WEST SUSSEX COUNTY COUNCIL CONSULTATION

TO:	Arun District Council FAO: Maria Tomalova
FROM:	WSCC - Highways Authority
DATE:	23 December 2020
LOCATION:	5 Richmond Avenue, Bognor Regis, PO21 2YE
SUBJECT:	BR/221/20/PL Detached garage with 1 No. flat above. This application is in CIL Zone 4 and is CIL Liable.
DATE OF SITE VISIT:	N/A
RECOMMENDATION:	Advice
S106 CONTRIBUTION TOTAL:	N/A

GROUND FLOOR PLAN

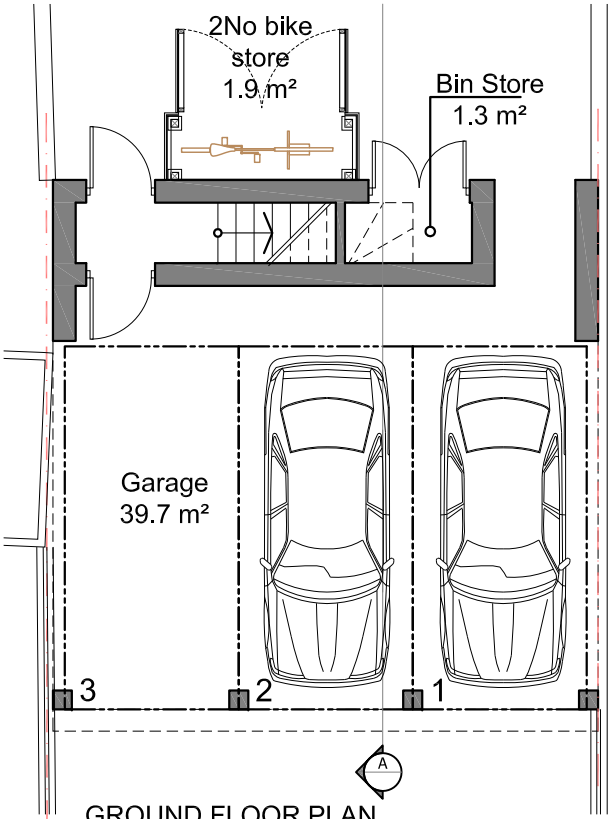
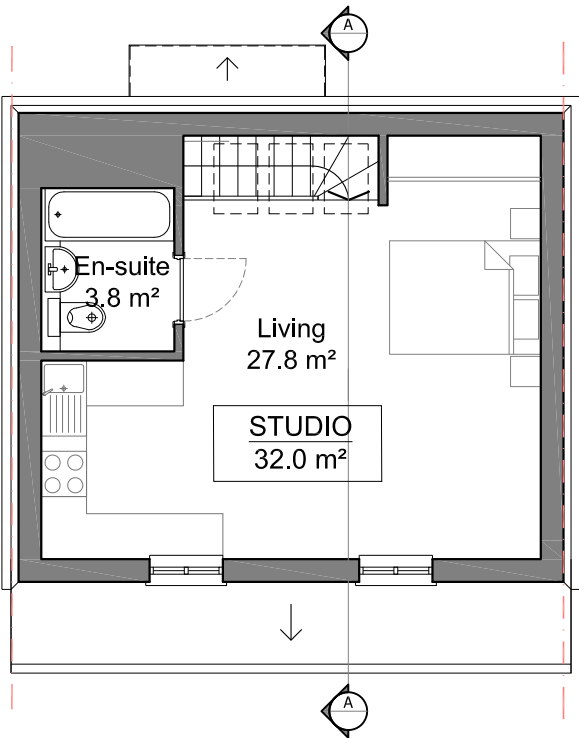
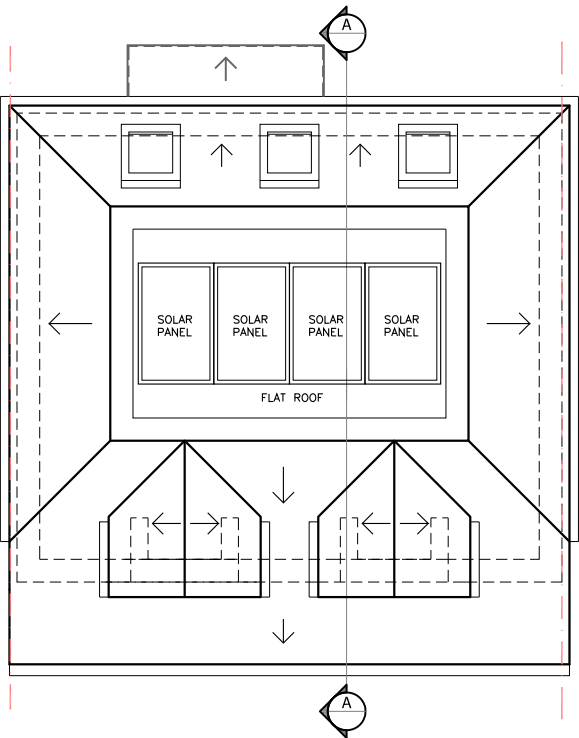
The LHA does note that the proposed garage bays have approximate dimensions of 2.3m x 4.8m, which does not meet the minimum specifications for single car garages of 3m x 6m as set out in Manual for Streets (MfS). Therefore, the LHA cannot consider them for parking provision, and advises the bays be enlarged to meet MfS specifications. Notwithstanding this, the LHA is satisfied that sufficient parking is available for the proposed dwelling.

Drawing Title:
PROPOSED SITE PLAN

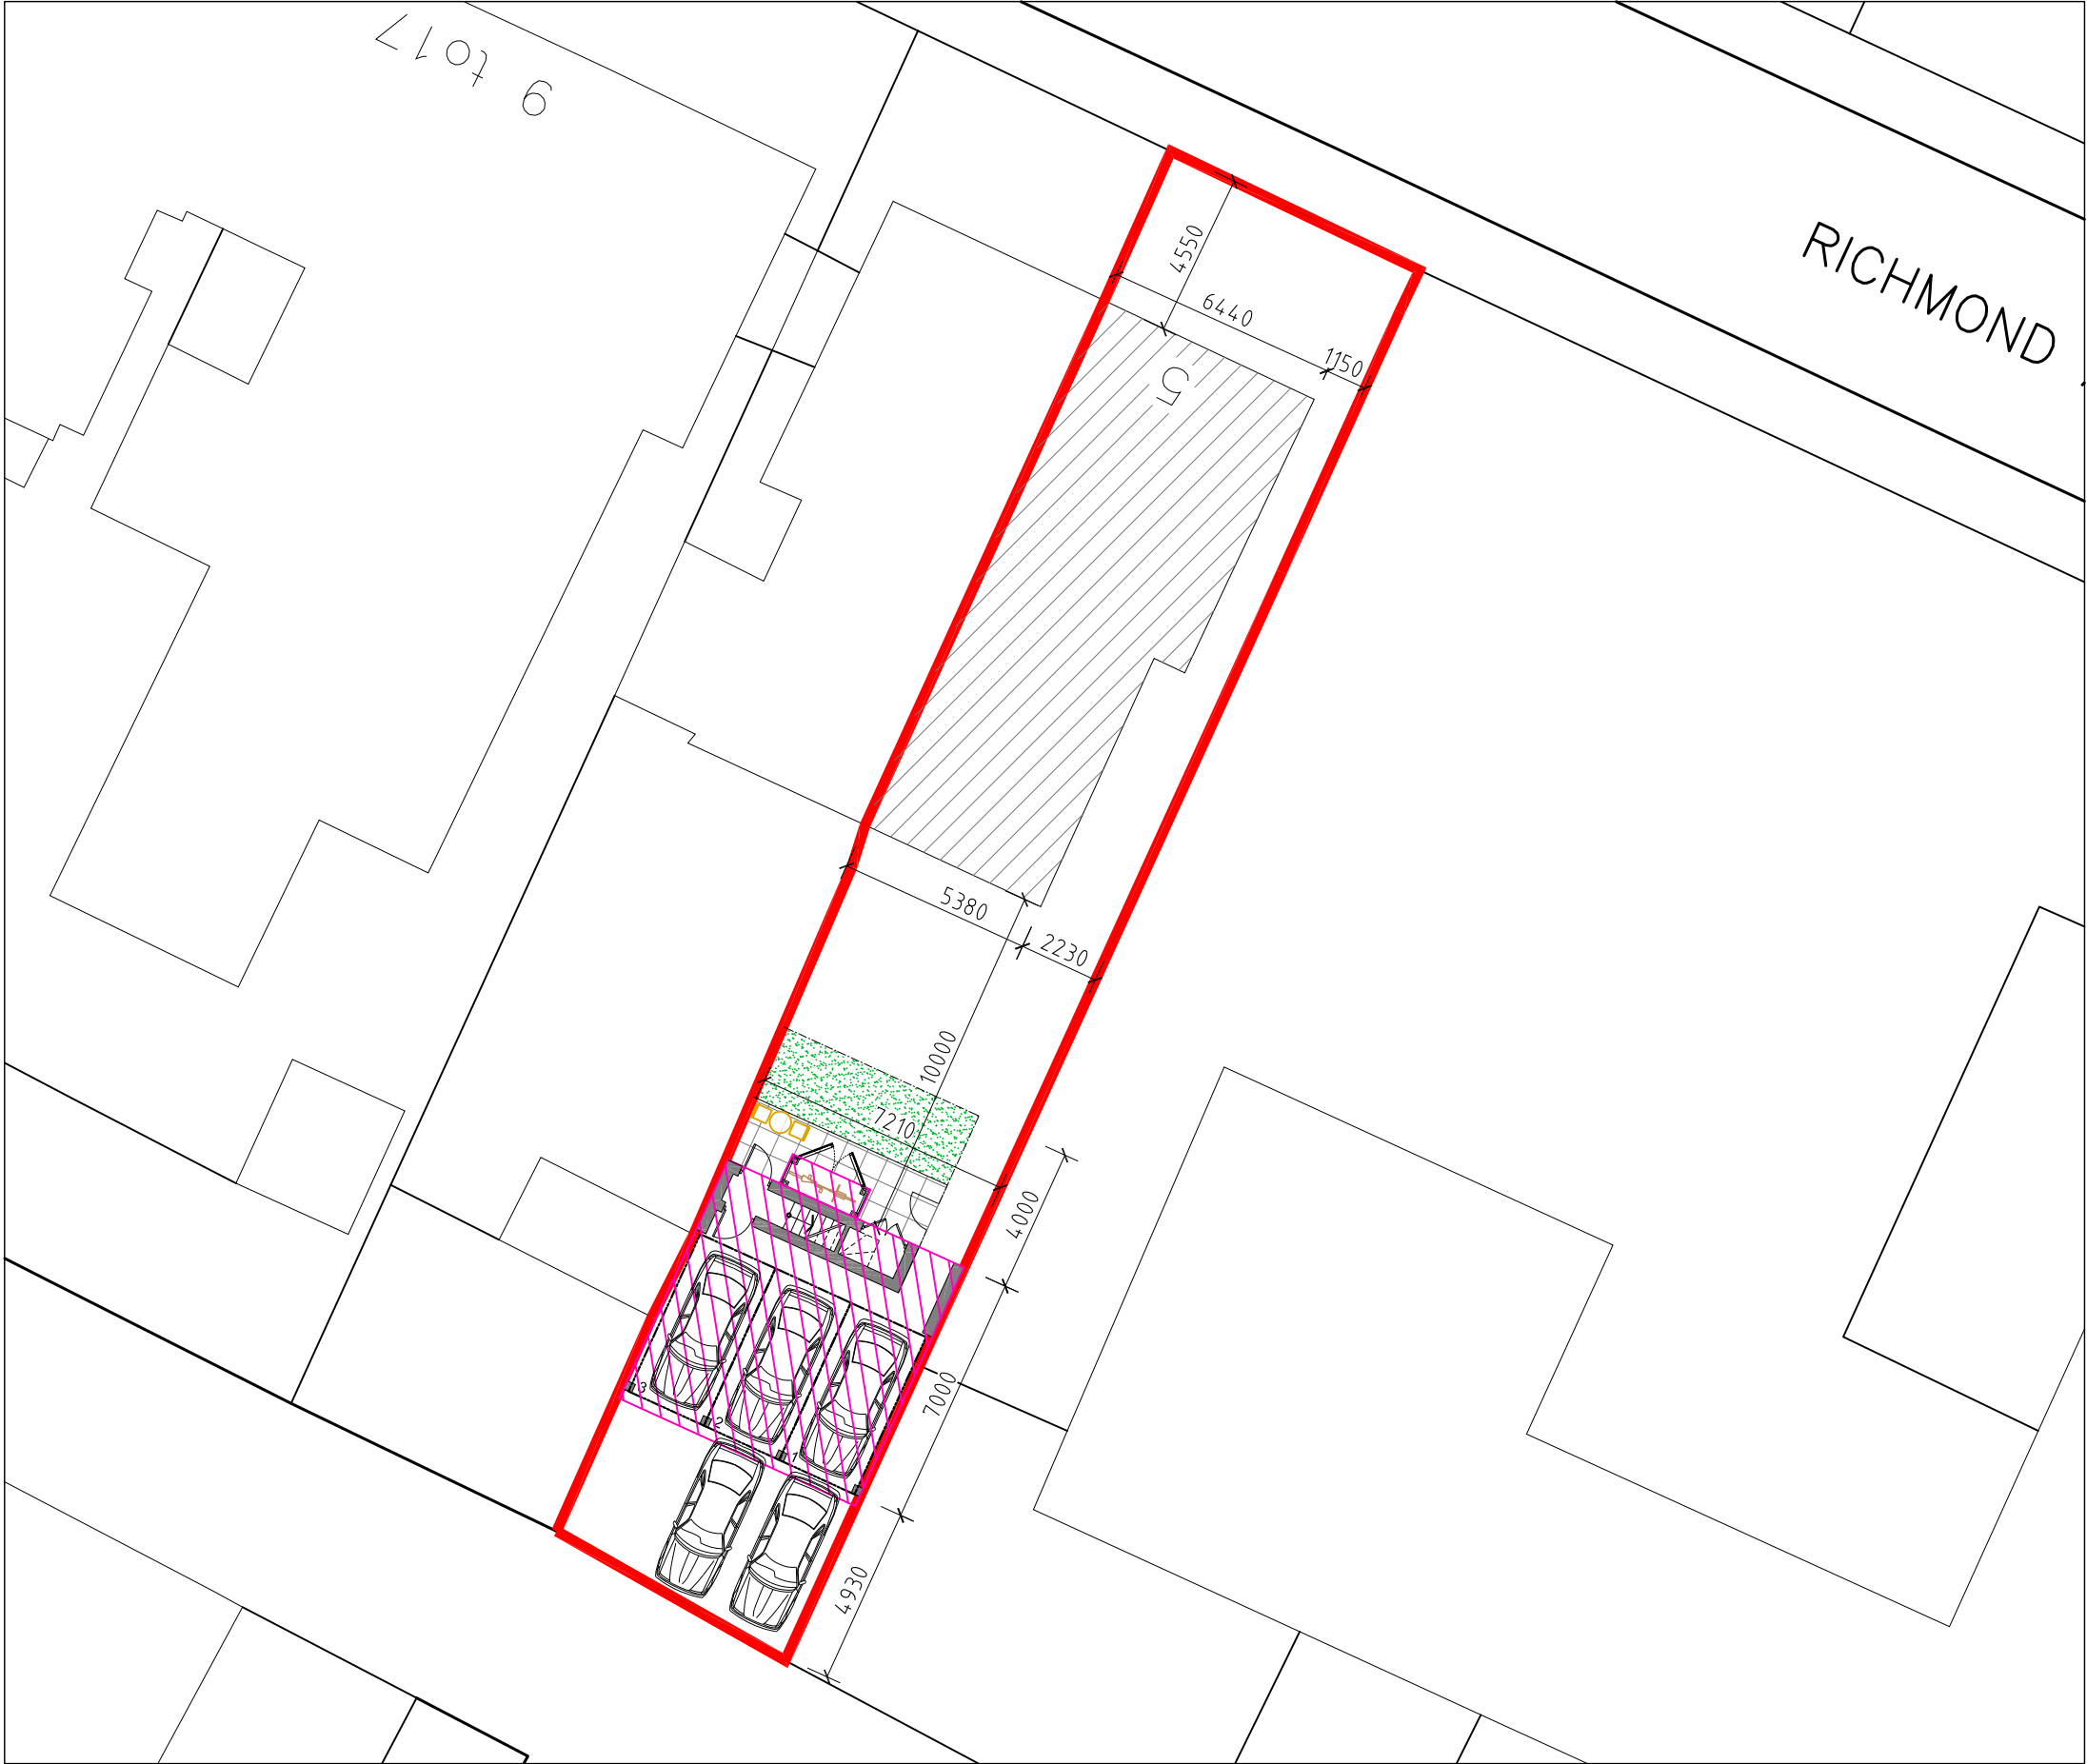
The site is situated on an existing informal parking area. The applicant proposes five car parking spaces that will be in place of the existing parking area. Arun Parking Standards require a dwelling of this size in this location to provide one car parking space. Therefore, the LHA considers the proposed parking provision to be sufficient. There is also adequate space within the private lane for vehicles to turn and exit onto the maintained highway in a forward gear.

Regarding cycle parking, the applicant has demonstrated cycle storage with provision for two cycles, in accordance with Arun Parking Standards. The inclusion of secure and covered cycle parking helps promote the use of sustainable transport methods.
